HANNAH RIDGE AT FEATHERGRASS FILING NO. 7

A REPLAT OF TRACT KK AND LL OF HANNAH RIDGE AT FEATHERGRASS FILING NO. 1,
RECEPTION NO. 214713468, RECORDS OF EL PASO COUNTY, COLORADO,
SECTION 32, TOWNSHIP 13 SOUTH, RANGE 65
WEST OF THE SIXTH PRINCIPAL MERIDIAN, EL PASO COUNTY, COLORADO

HANNAH RIDGE AT FEATHERGRASS
FILING NO. 7
JOB NO. 1116.07
OCTOBER 4, 2018
SHEET 1 OF 3

HANNAH RIDGE AT FEATHERGRASS
FILING NO. 7
JOB NO. 1116.07
OCTOBER 4, 2018
SHEET 2 OF 3

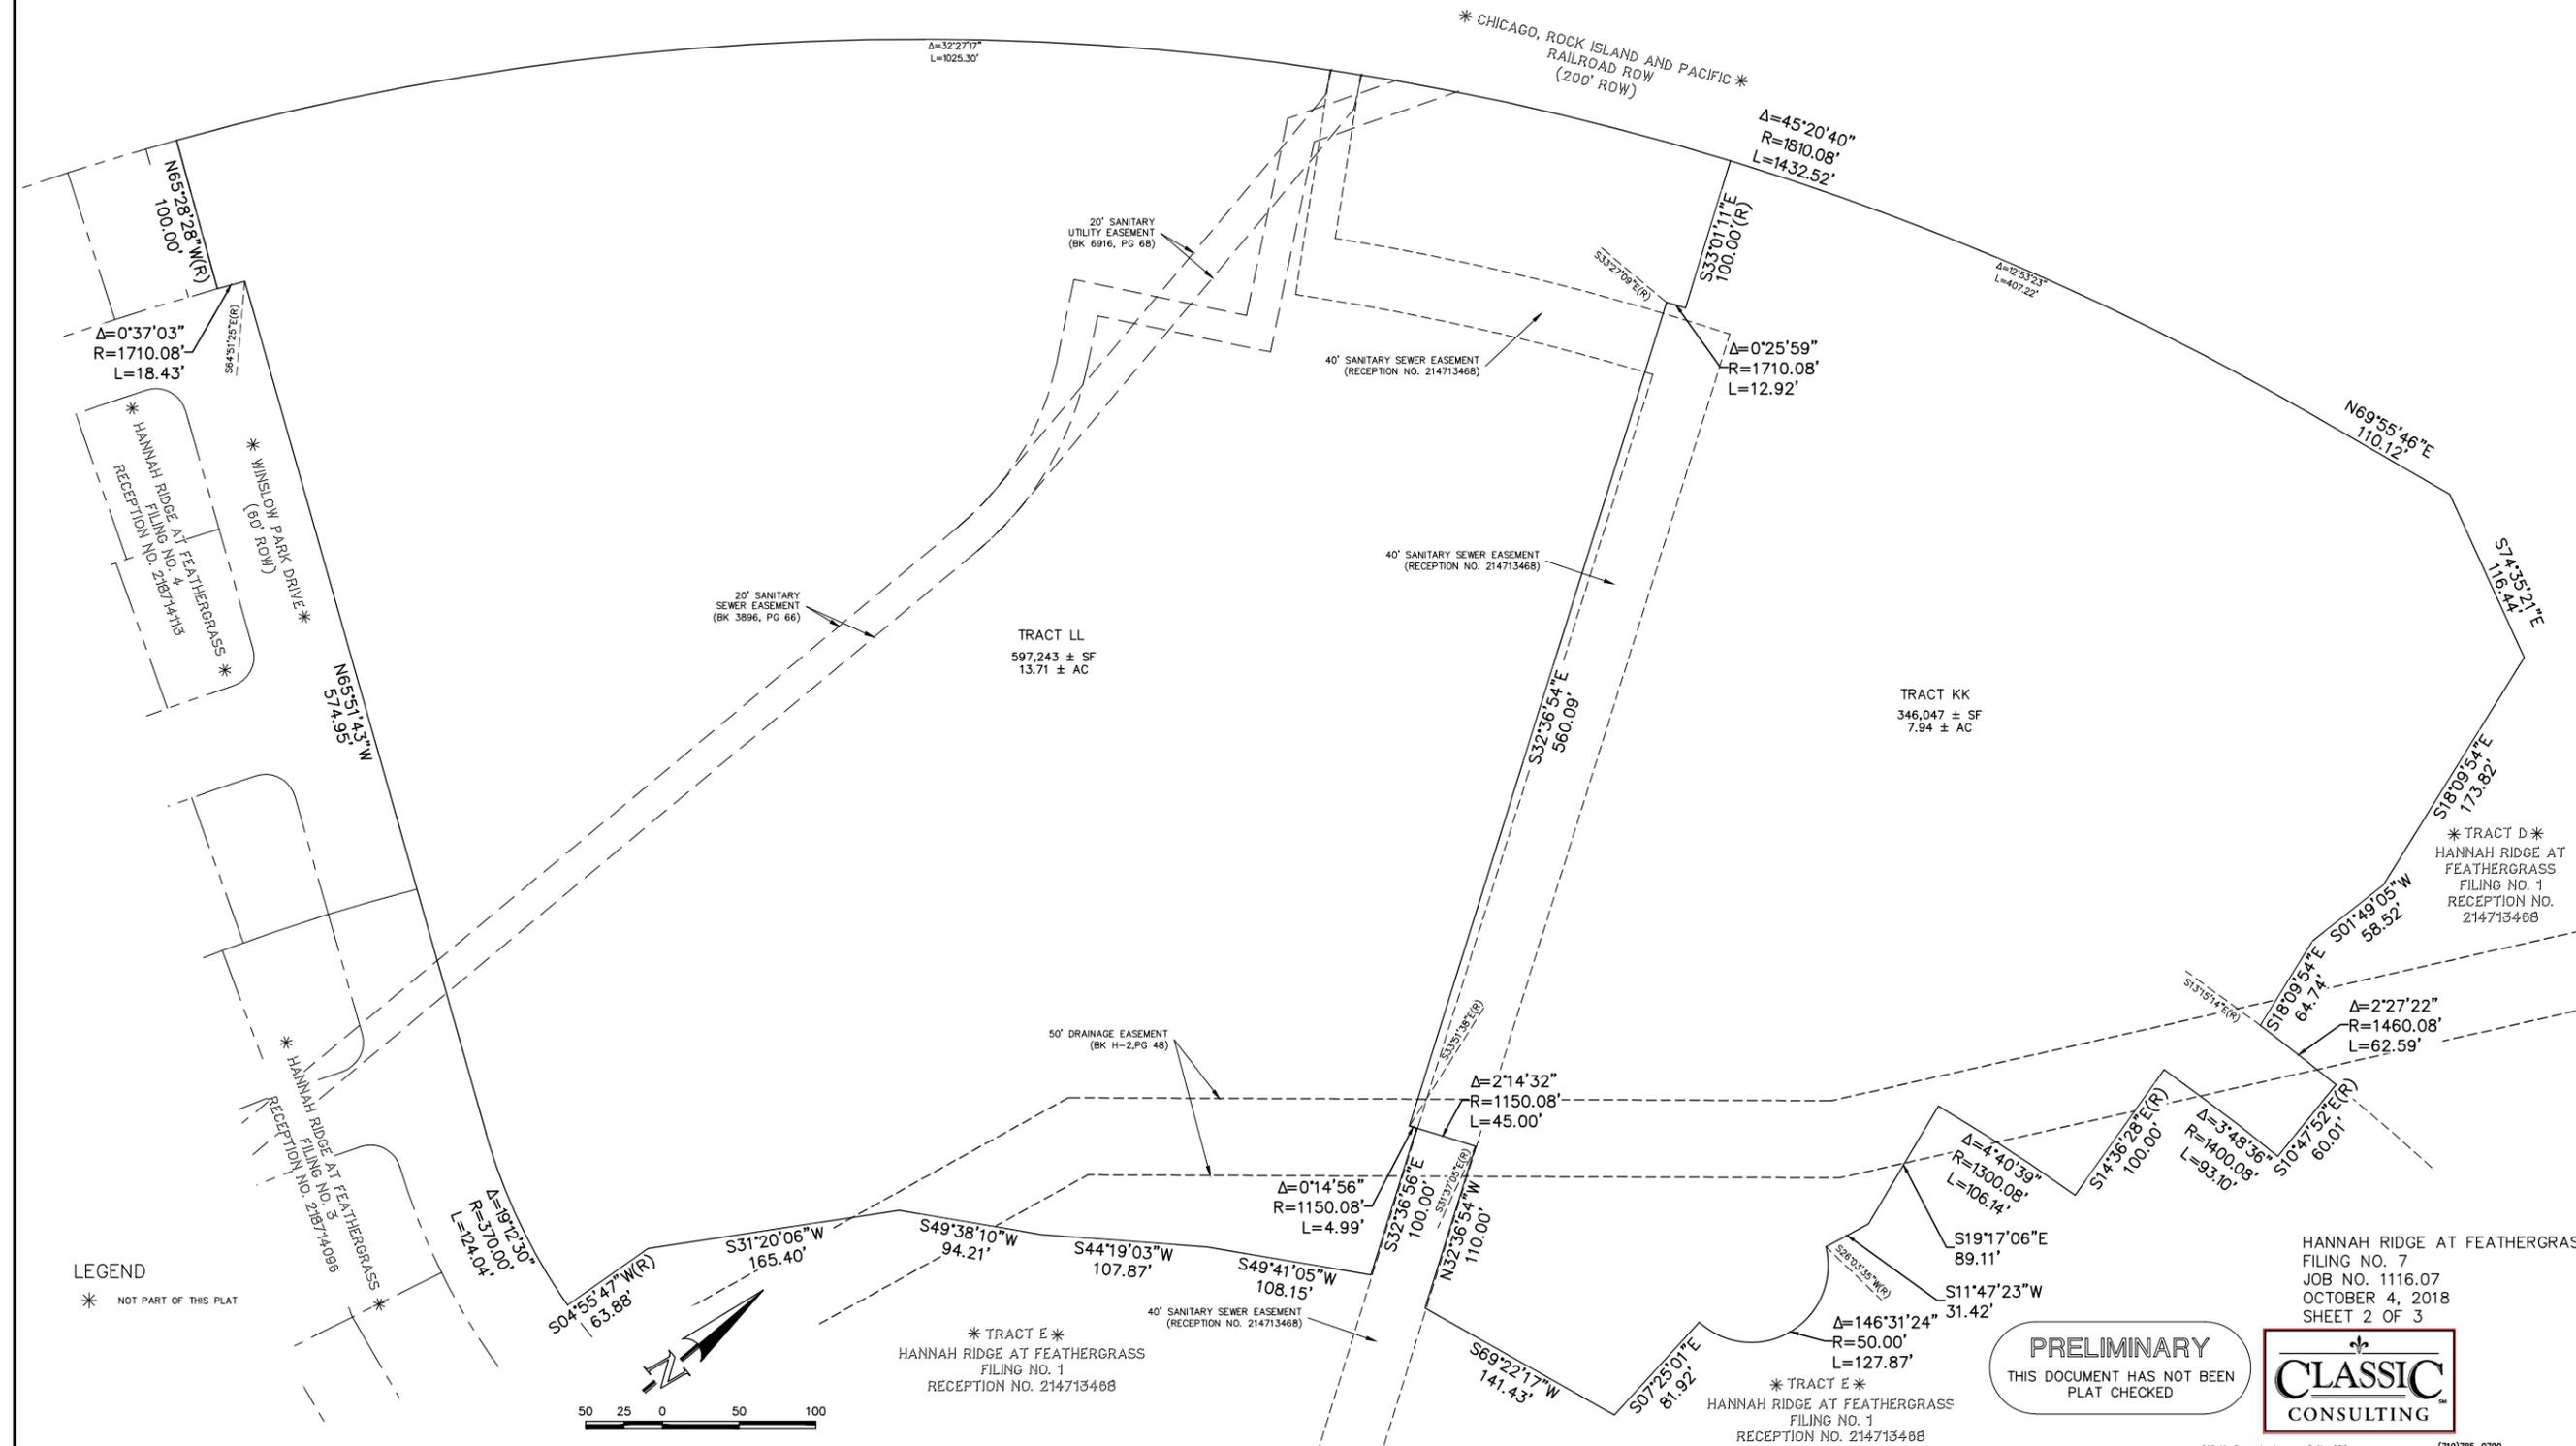
Can you add the line
work for whats been
platted so we can see
the overall
connectivity to the is
map?
